Charlotte Department of Transportation

Memorandum

Subject: Rezoning Petition 08-066: Located on the northwest corner of North Tryon Street and West W.T. Harris Boulevard (Revised 4/18/08)

**SITE PLAN/
TECHNICAL
DATA SHEET**

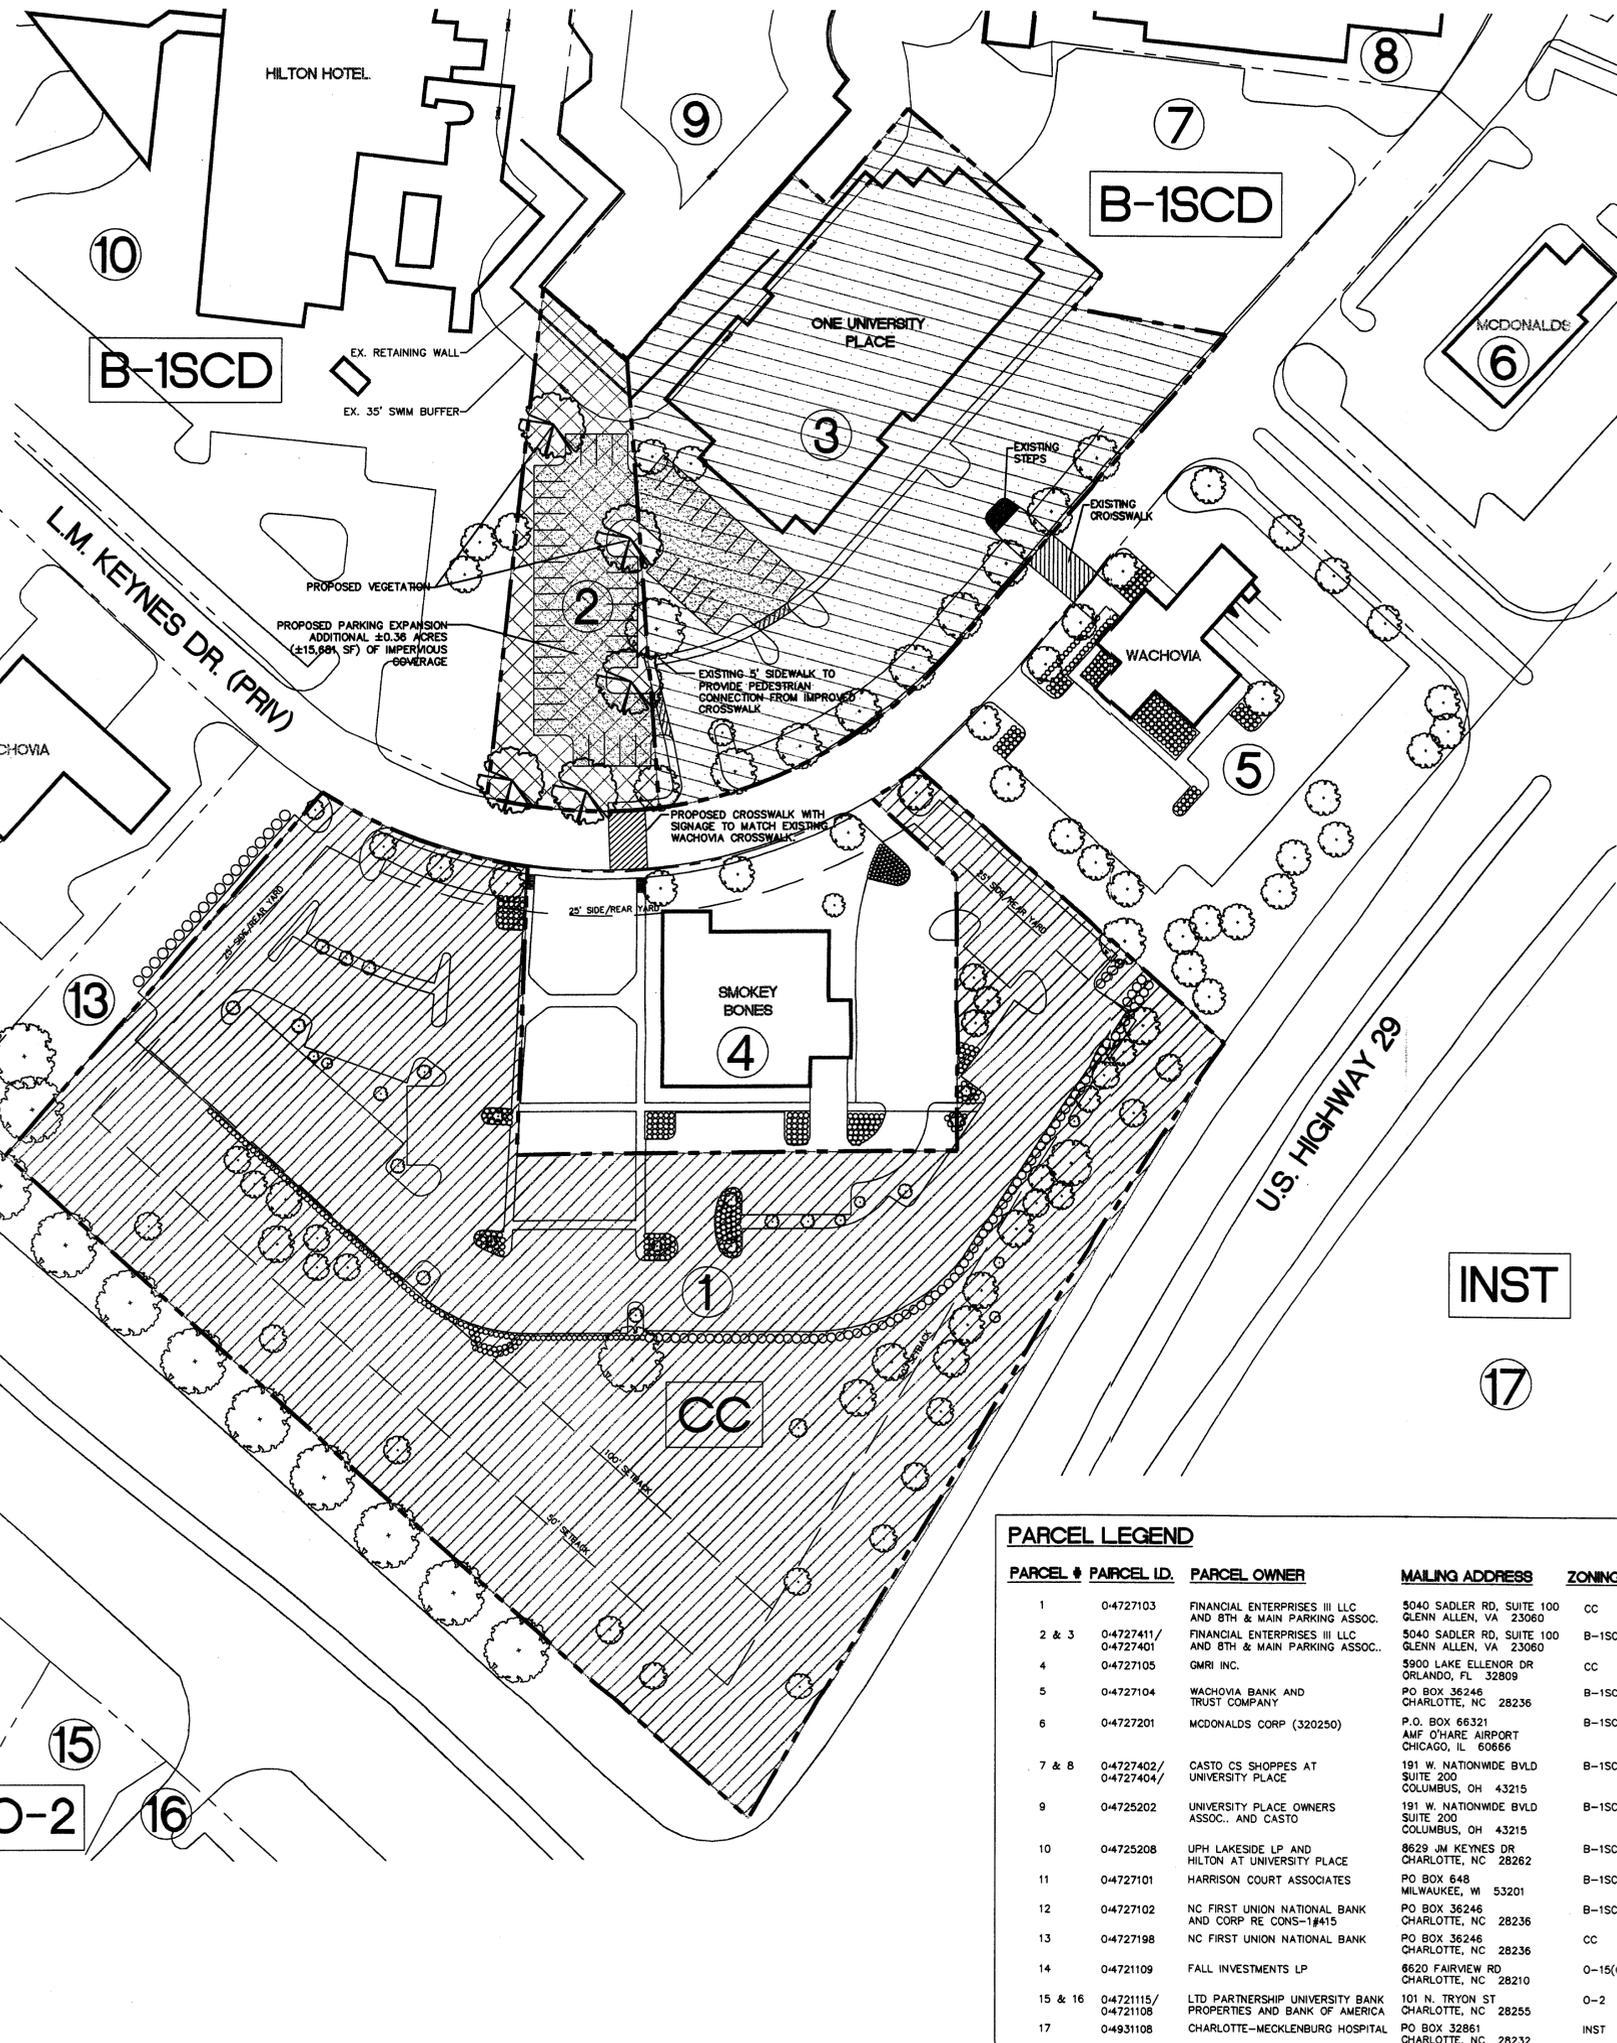
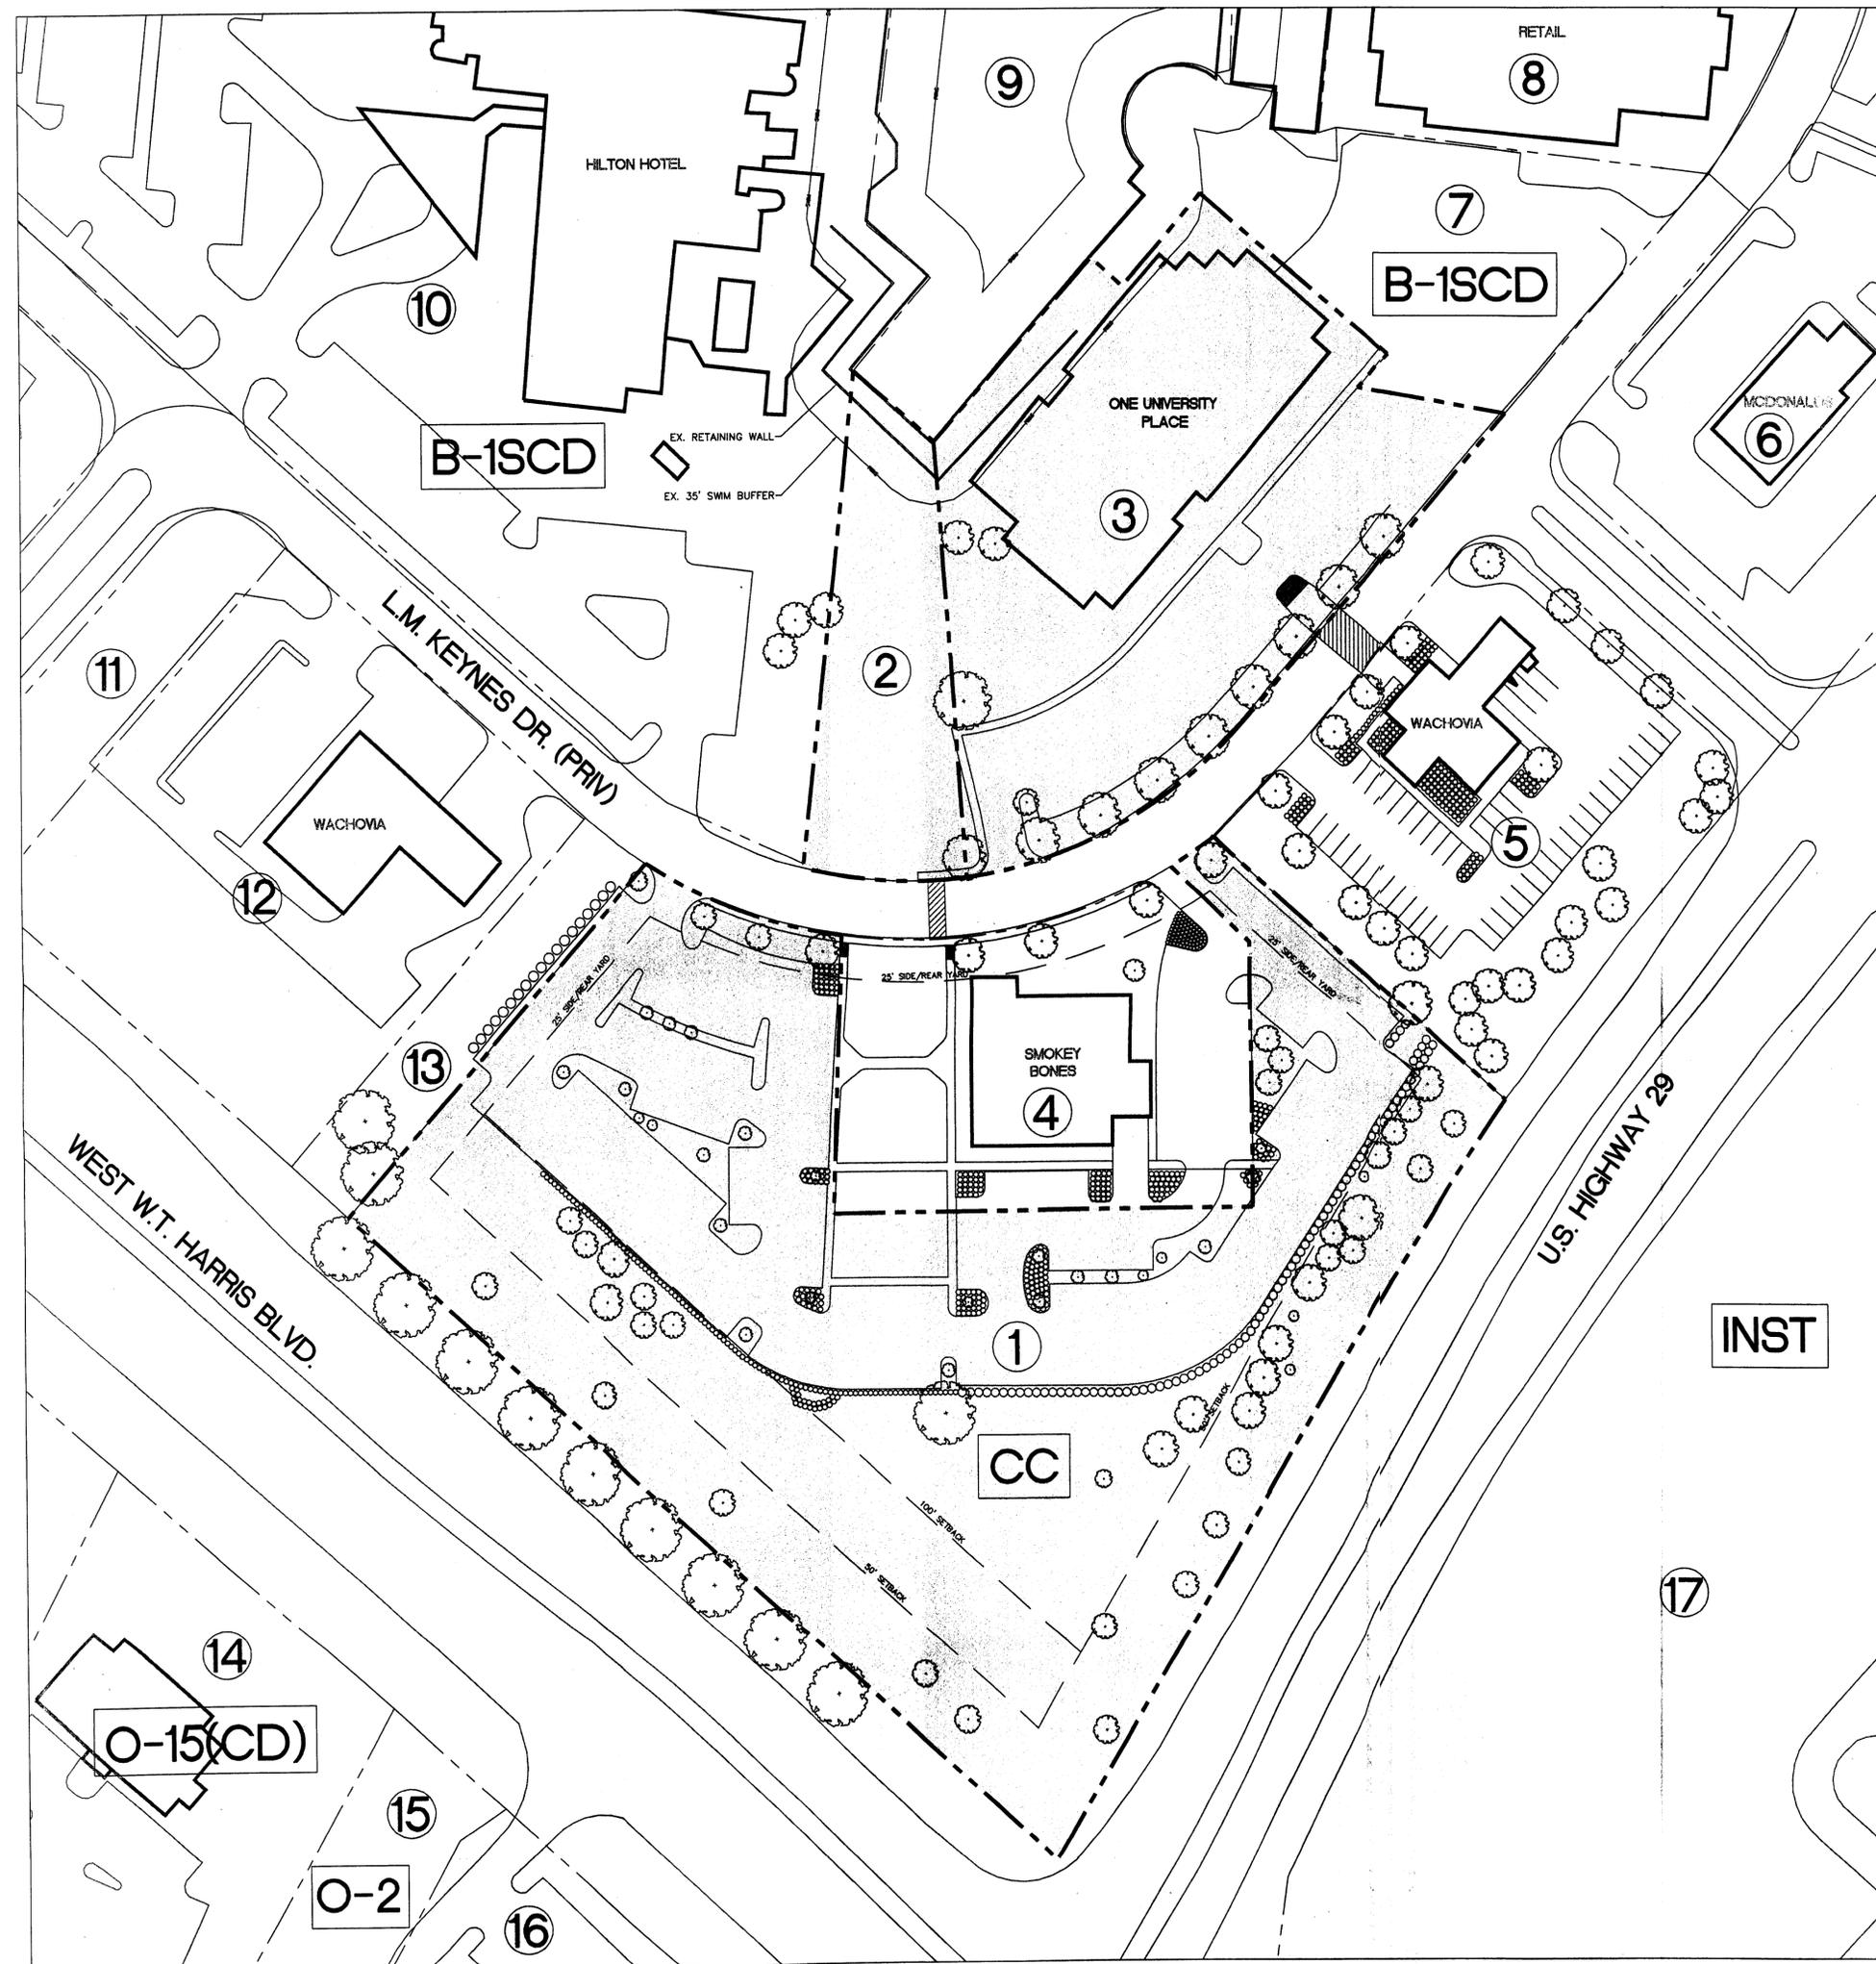
1. Curb and gutter and 6-foot sidewalk need to be constructed along the site's North Tryon Street frontage. (*Previous review comment*)
2. A 10-foot shared bike/pedestrian trail needs to be constructed along the site's WT Harris Boulevard frontage. (*Previous review comment*)
